Ribble Valley Borough Council
By email

Your ref 3/2024/0037
Our ref DC/24/448
Date 05-MAR-24

Location: Land adjacent to 7 and 9 Windy Street PR3 2GD

Proposal: Proposed drilling of two boreholes for ground source heating purposes and associated underground pipe work

Drawing file: planx_downloads / 24_0037_Site_Plan.pdf

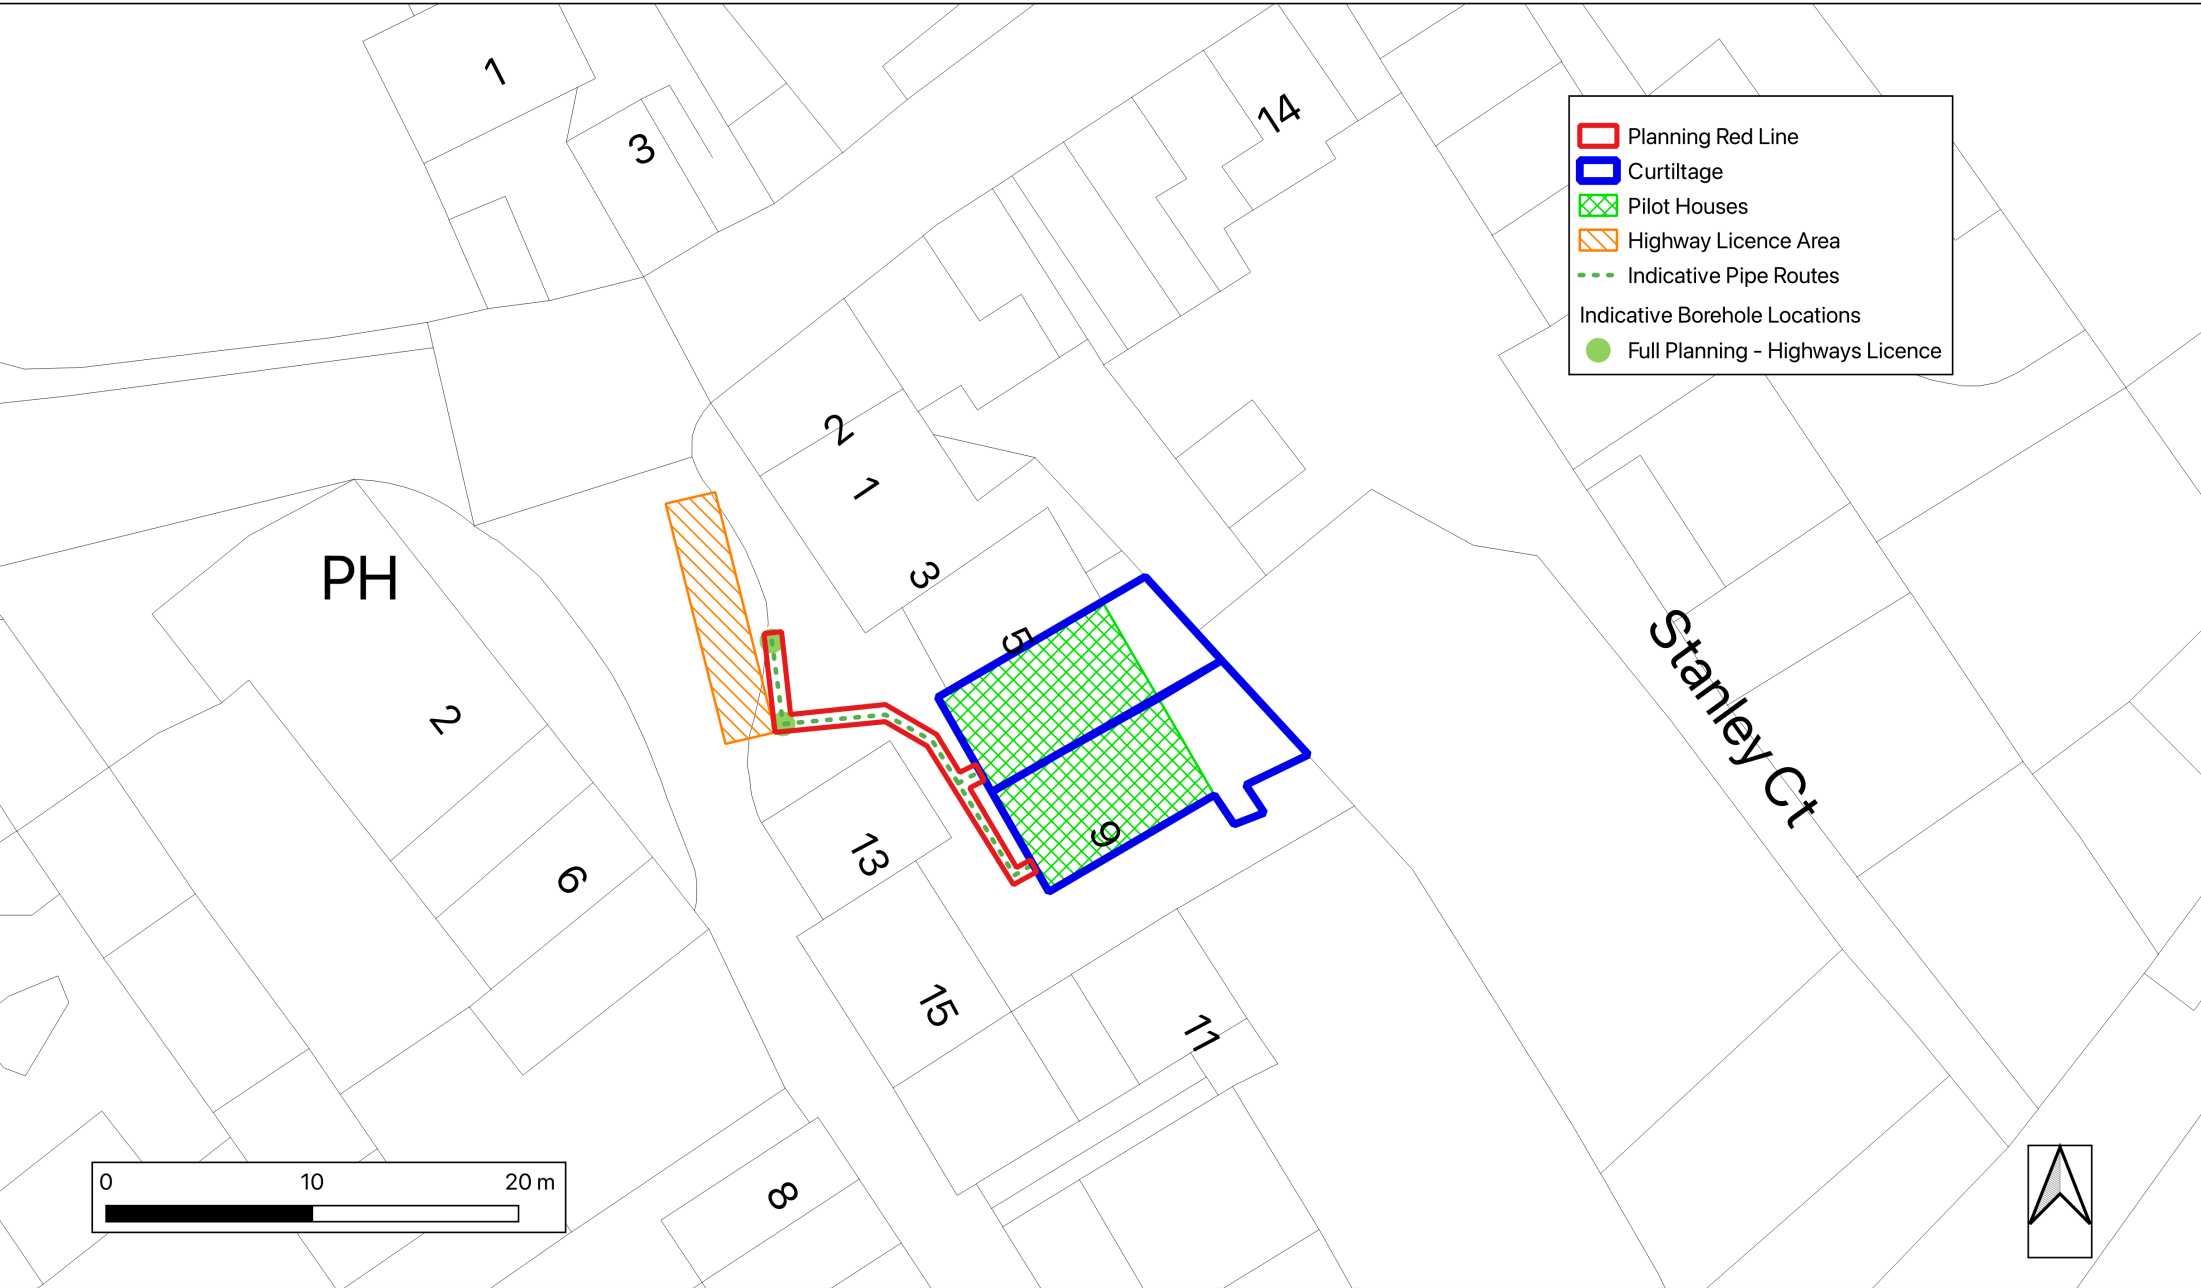
Following our review of the proposed site layout, we can confirm that the proposal is not acceptable to United Utilities as proposed features appear to be located above/in close proximity to our combined sewer.

Noting this is a Full application, we request that the applicant provides a detailed plan, and that United Utilities has the opportunity to review and comment on this plan PRIOR TO DETERMINATION of this application. This should include detail of the type of heat source

installation (i.e. vertical or horizontal) and to what depth this will be installed. We request that the public sewer's line and depth is accurately located and overlaid on any plans and a 3m easement is kept between the ground loop and the centre line of the public sewer.
